PLANNING CONSULTATION RESPONSE

Application No	2026/0246
Proposal	Conversion of existing roofspace to create 3x residential flats, with associated external alterations including installation of rooflights.
Address	Family Shopper, West Street, Hoyland, Barnsley, S74 9DU
Date of Consultation Reply	13/08/2026
Consultee	Pollution Control

TYPICAL LONGITUDINAL SECTION

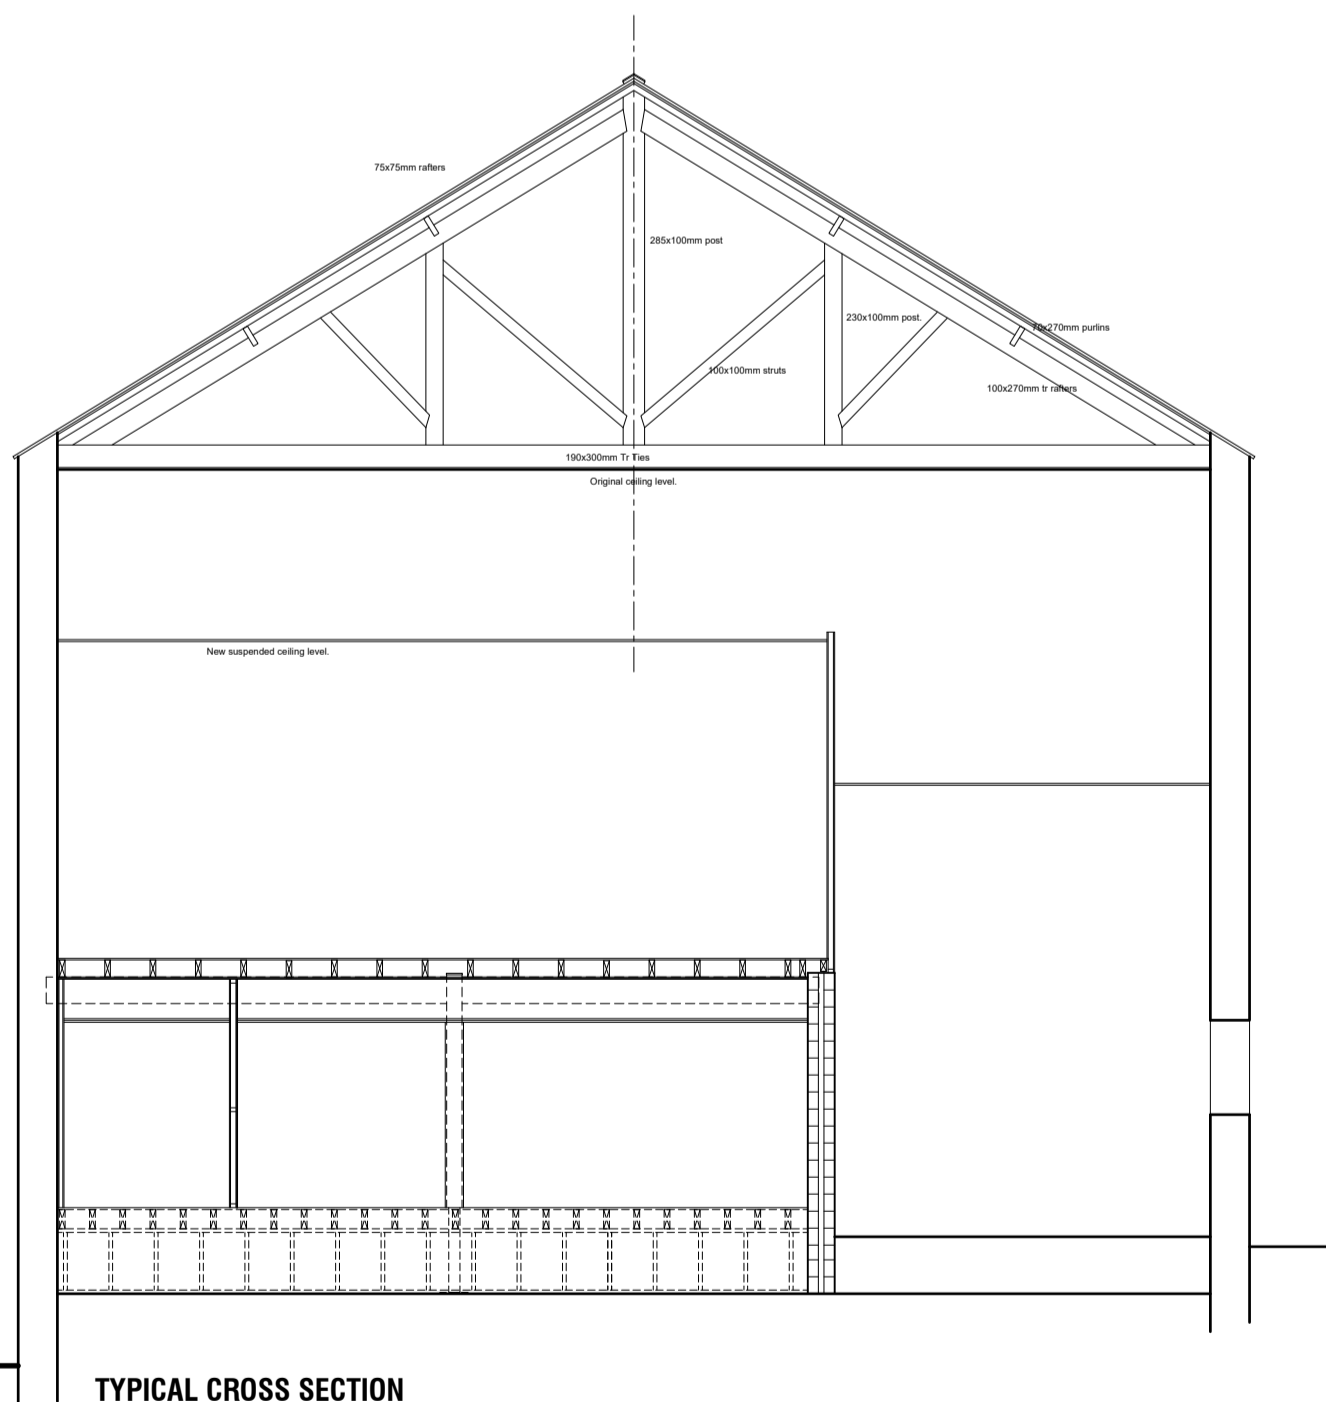
The proposed development is located above a dance studio and gymnasium, both of which are likely to be sources of noise which could transfer to the proposed accommodation if adequate acoustic insulation between the floors is not provided. Sound insulation testing is required in order to ensure sound transference is minimised between floors 1 and 2.

Before the development is occupied a noise breakthrough assessment shall be carried out and a report provided to the Local Planning Authority which shall confirm adequate sound insulation has been provided between the domestic and non-domestic premises. The report shall indicate that the internal noise criteria as stated in BS8233 has been achieved and meets the standards in Approved Document E of current Building Regulations.
